**WEST SUSSEX COUNTY COUNCIL
STRATEGIC PLANNING CONSULTATION**

**SUBJECT: LU/303/13 - removal of condition 24 (bus access) following outline
application LU/355/10**

Land South of Courtwick Park, Courtwick Lane, Littlehampton, West Sussex

Rev.	Date	Description	Drawn	Checked
Client: BARRATT Bellway aan Project: Courtwick Littlehampton Drawing Title: Bus Route Location Plan				
Scale:	1:1000 @ A1	Drawn:	BAS	Checked:
Date:	Sept 2012	File:	P802/Layout	Drawn/Checked:
By:	P802/BR/01	Rev.:		Preliminary

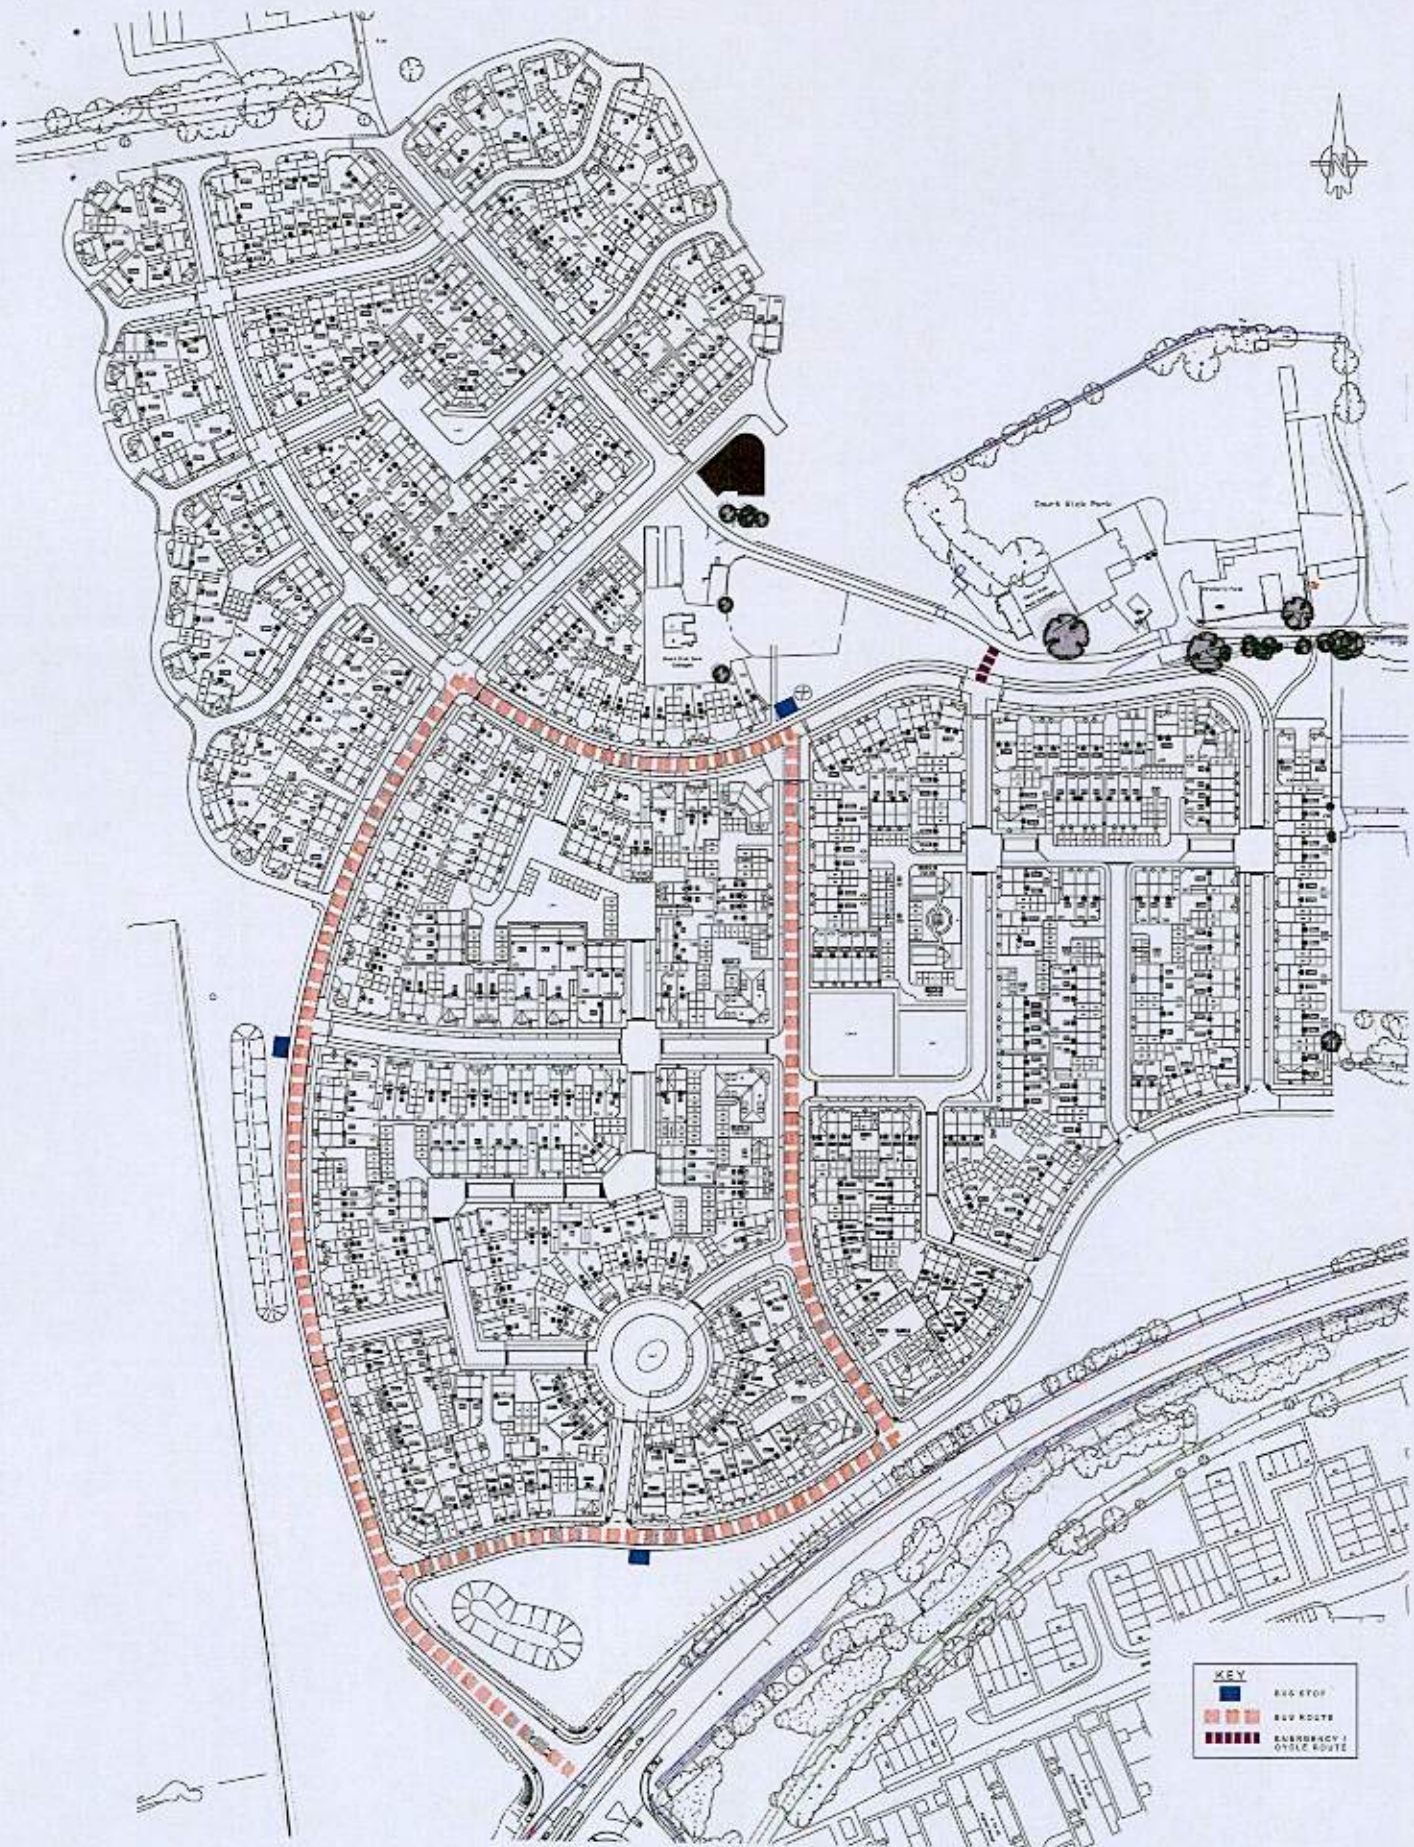
An alternative has been given for a bus route serving the site. The rationale behind the proposal to remove the condition is understood. The County Council wishes to see an approach which keeps options open for serving the site by bus. The applicants are therefore requested to discuss with the County Council (and the town council and all local bus operators) whether and how bus services could be provided, with the widest possible range of options on the table.

PROPOSED BUS ACCESS ARRANGEMENTS
SWEEP PATH ANALYSIS - SINGLE DECK BUS AND TRACTOR

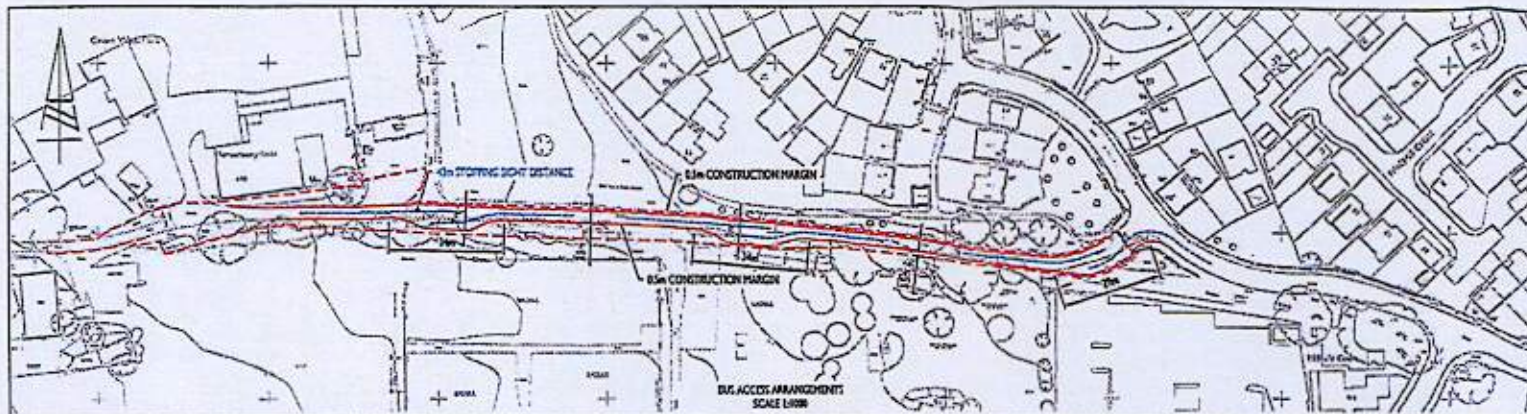
It is not clear whether, if the bus access was removed, the pedestrian, bicycle and emergency access would still be implemented. Confirmation of the developers' intention on this issue would be welcomed.
